Recommendation Report for Planning Permission for Works or Extension to a Dwelling

REF NO: FP/196/20/HH

LOCATION: 68 Downview Road
Felpham
PO22 8JA

PROPOSAL: Single storey front porch extension & first floor extension over garage.

PROPOSED 1ST FLOOR AND PORCH EXTENSIONS AT 68, DOWNVIEW ROAD, FELPHAM
FOR MR. & MRS. P. GARDNER

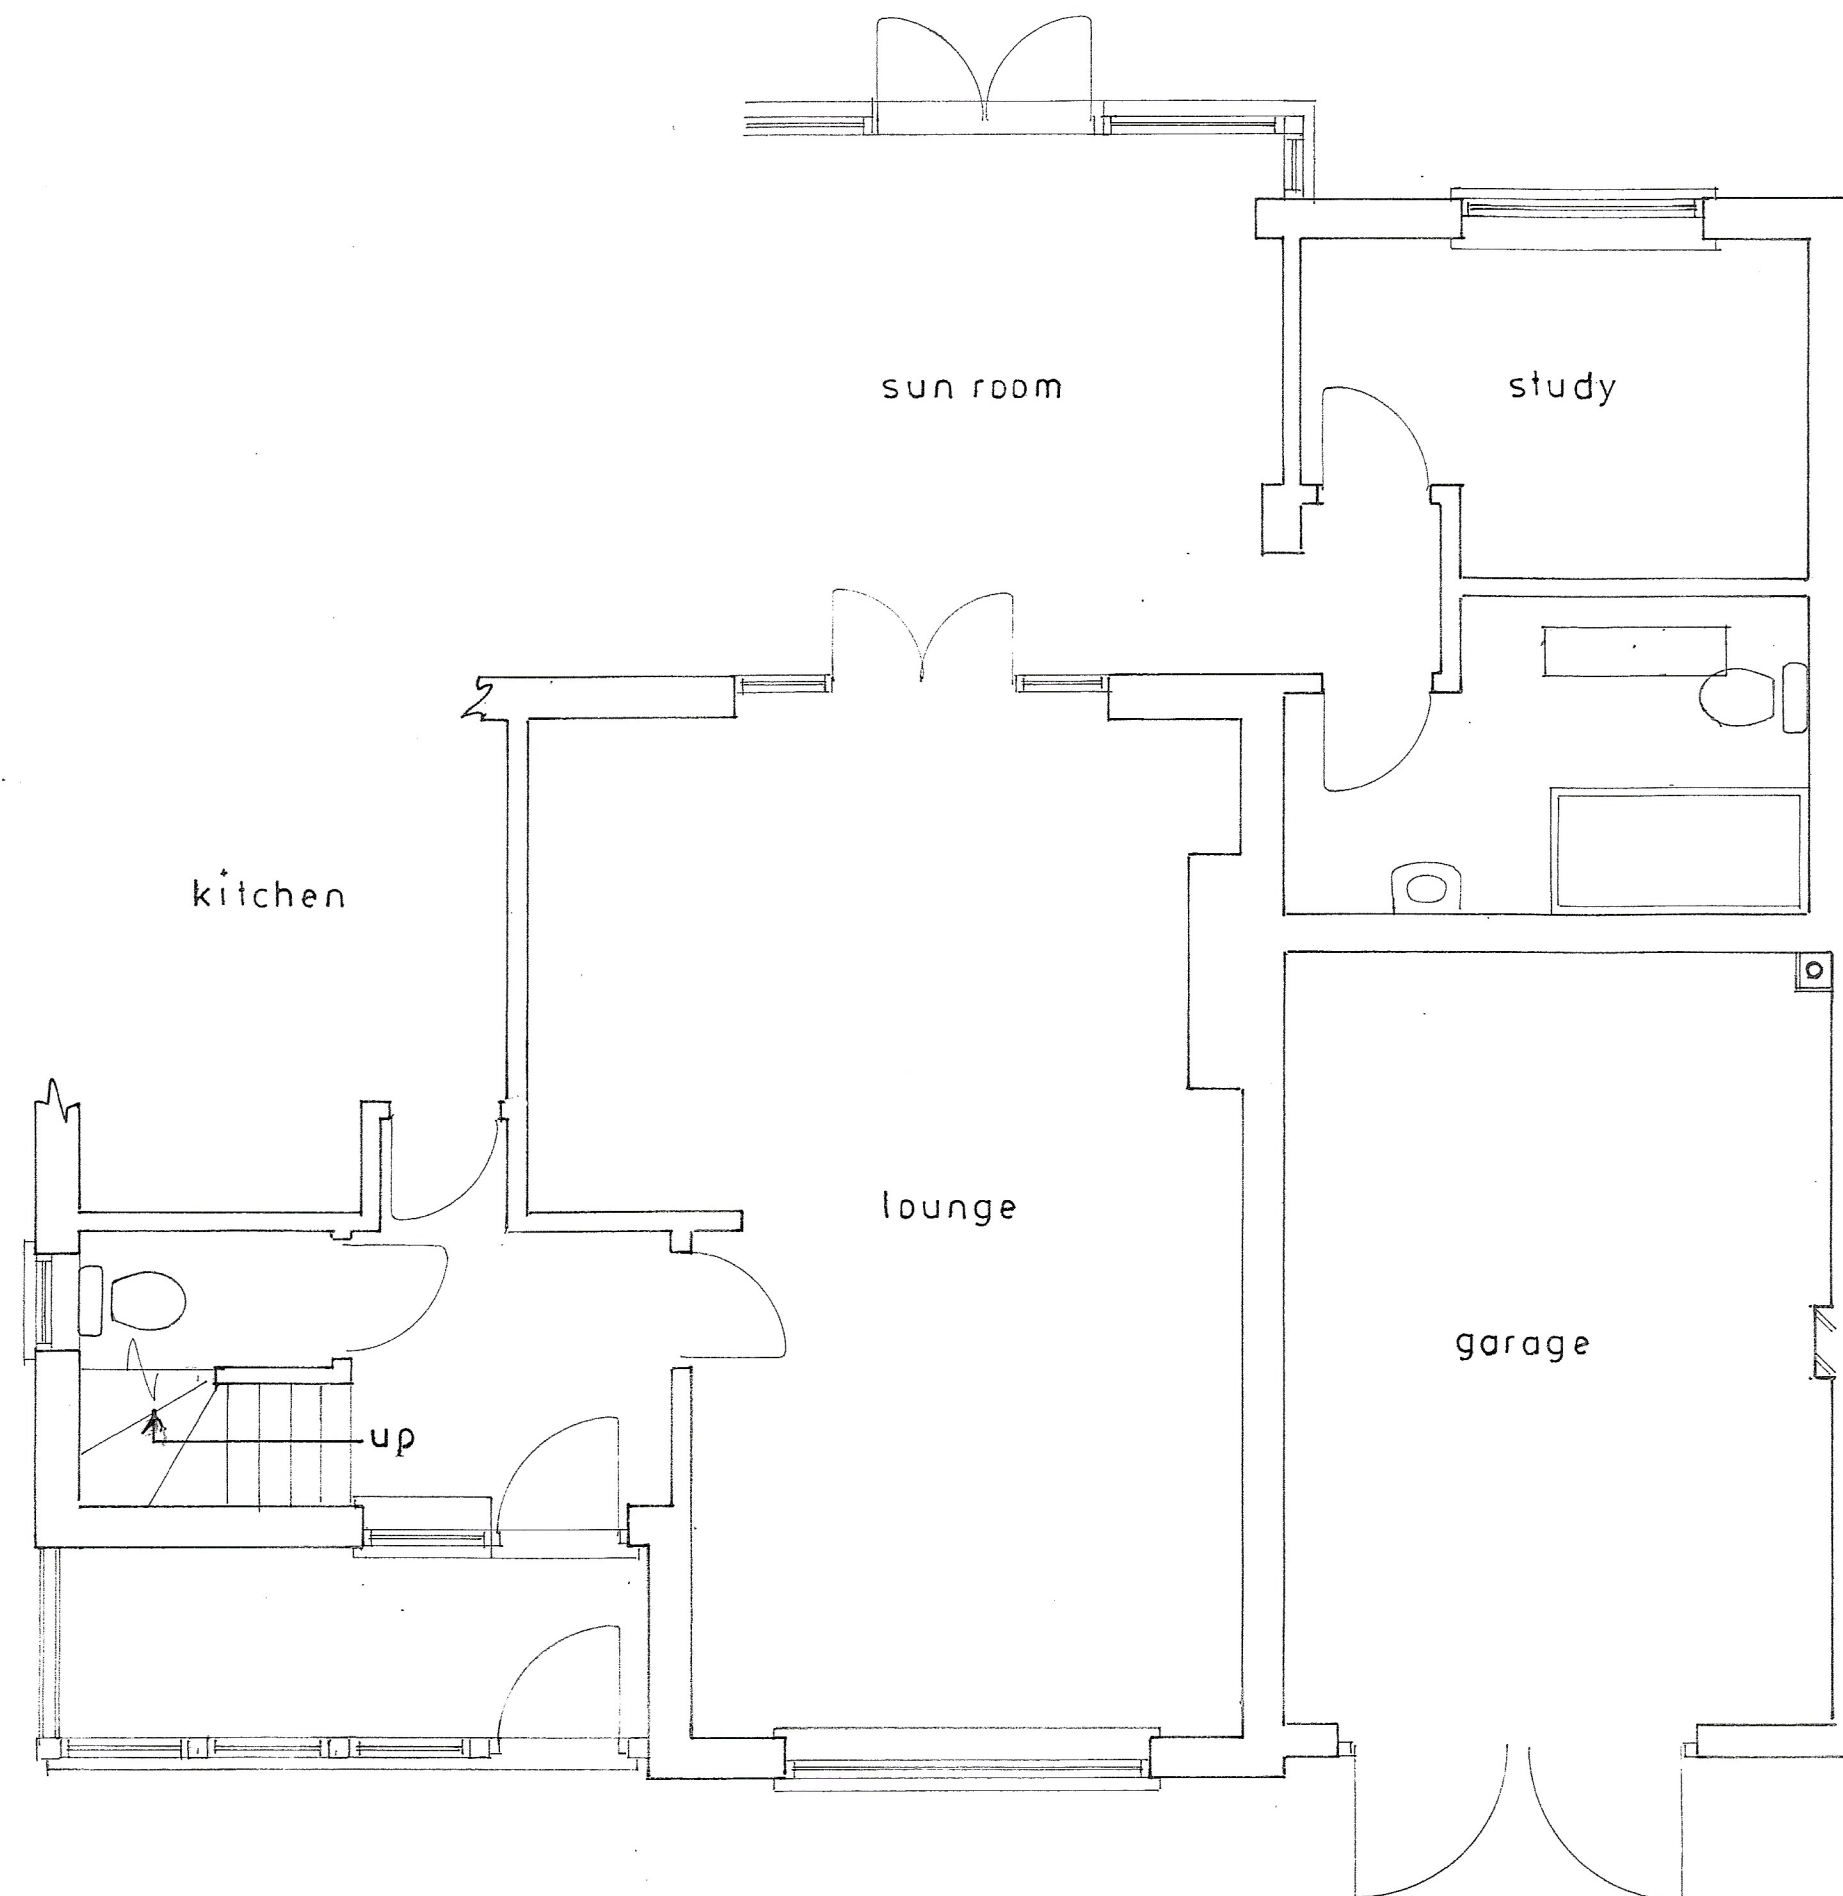
There will be a front porch to the west elevation with a width of 4.2m and depth of 1.6m. This is smaller in scale with a flat roof and considered acceptable.

PROPOSED 1ST FLOOR AND PORCH EXTENSIONS AT 68, DOWNVIEW ROAD, FELPHAM
FOR MR. & MRS. P. GARDNER

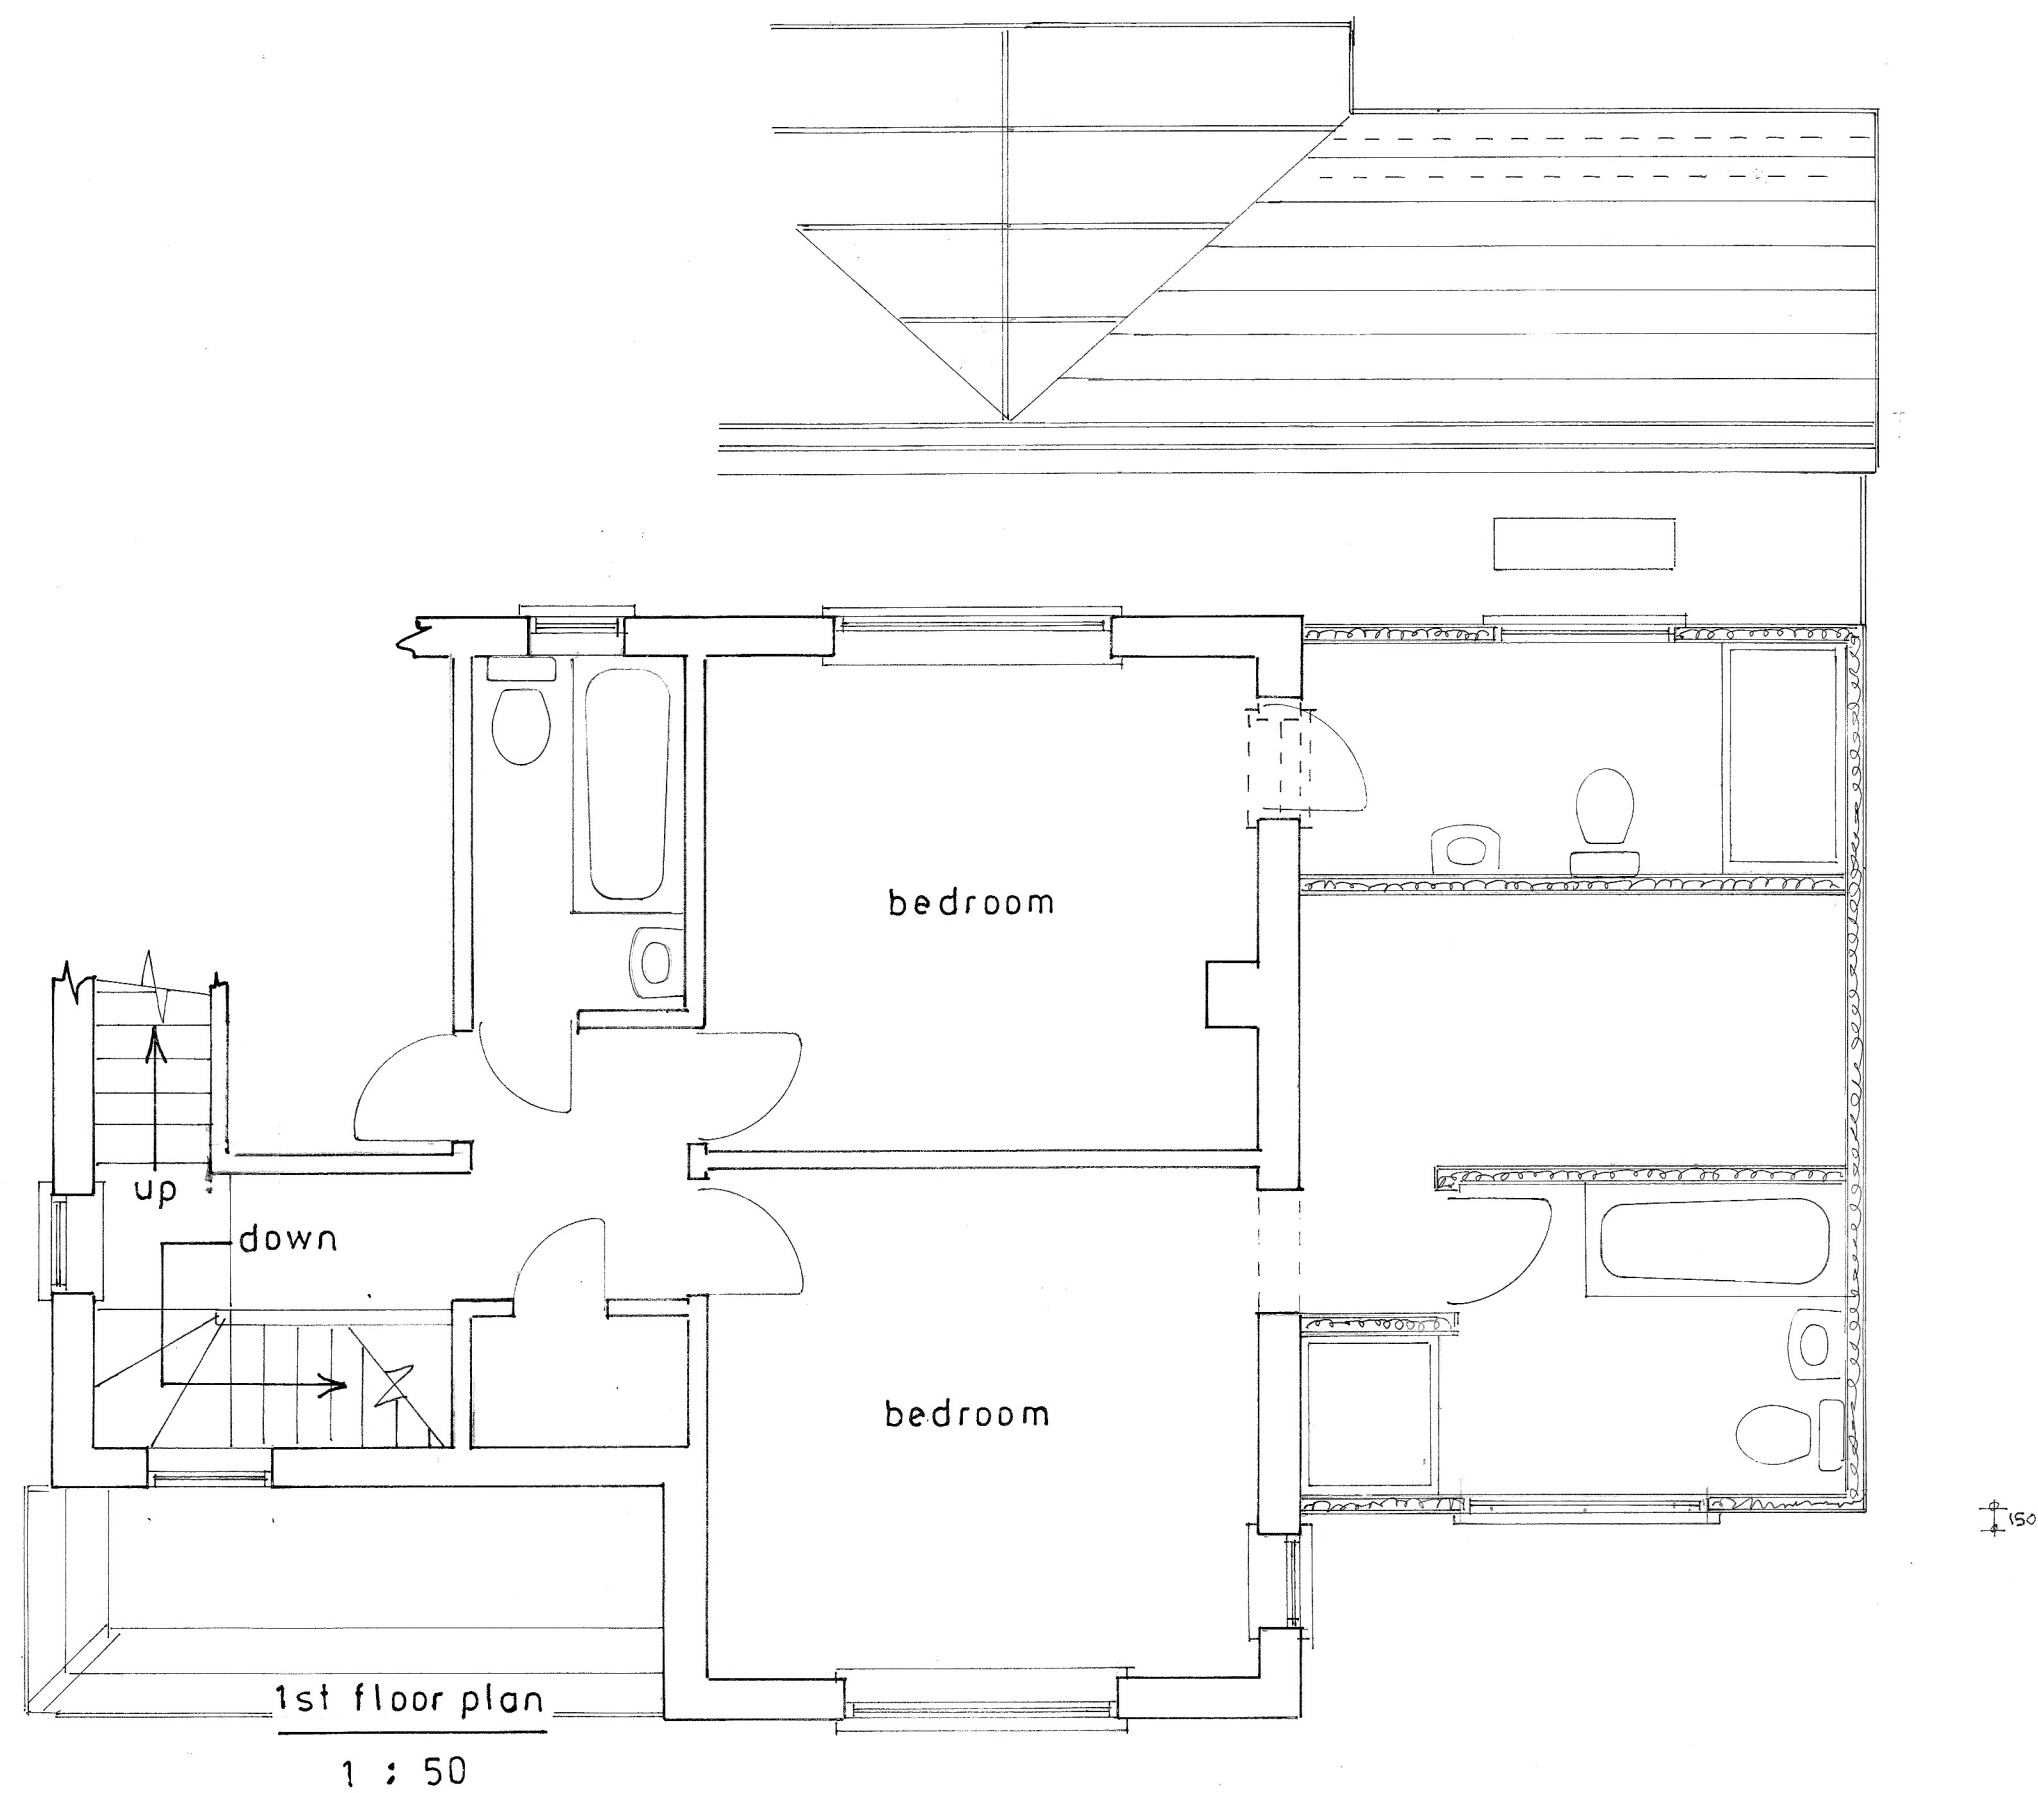
The property has a garage to the side elevation and this will be extended 5.25m in height allowing a first floor to be added which will run alongside the southern boundary with a depth of 5.9m. The extension will have a height which matches that of the ridge of the existing dwelling.

The extension to the top of the garage will have a gable roof and will abutt the side boundary.

Due to the size, the proposal adds additional bulk to the side elevation and as a result of the siting of the neighbouring property at No.66 which is located parallel to the host dwelling, it is considered to result in an oppressive and overbearing effect on the amenity no 66 including that of the first floor dormer. The two storey addition will have a significantly detrimental impact on the occupiers at No.66 due to the bulk and proximity resulting in an unneighbourly form of development.

As a result of the siting and size of the development, it is deemed to give rise to unacceptable adverse overbearing impact upon the occupiers at No.66 and as such is in conflict with D DM1 (3) and D DM4 (c) of the Arun Local Plan. Policy ESD1 of the Neighbourhood Plan states that development should be 'appropriate to its location'. The proposal conflict with this in such that size of the development is not appropriate for its locality abutting the boundary with No.66.
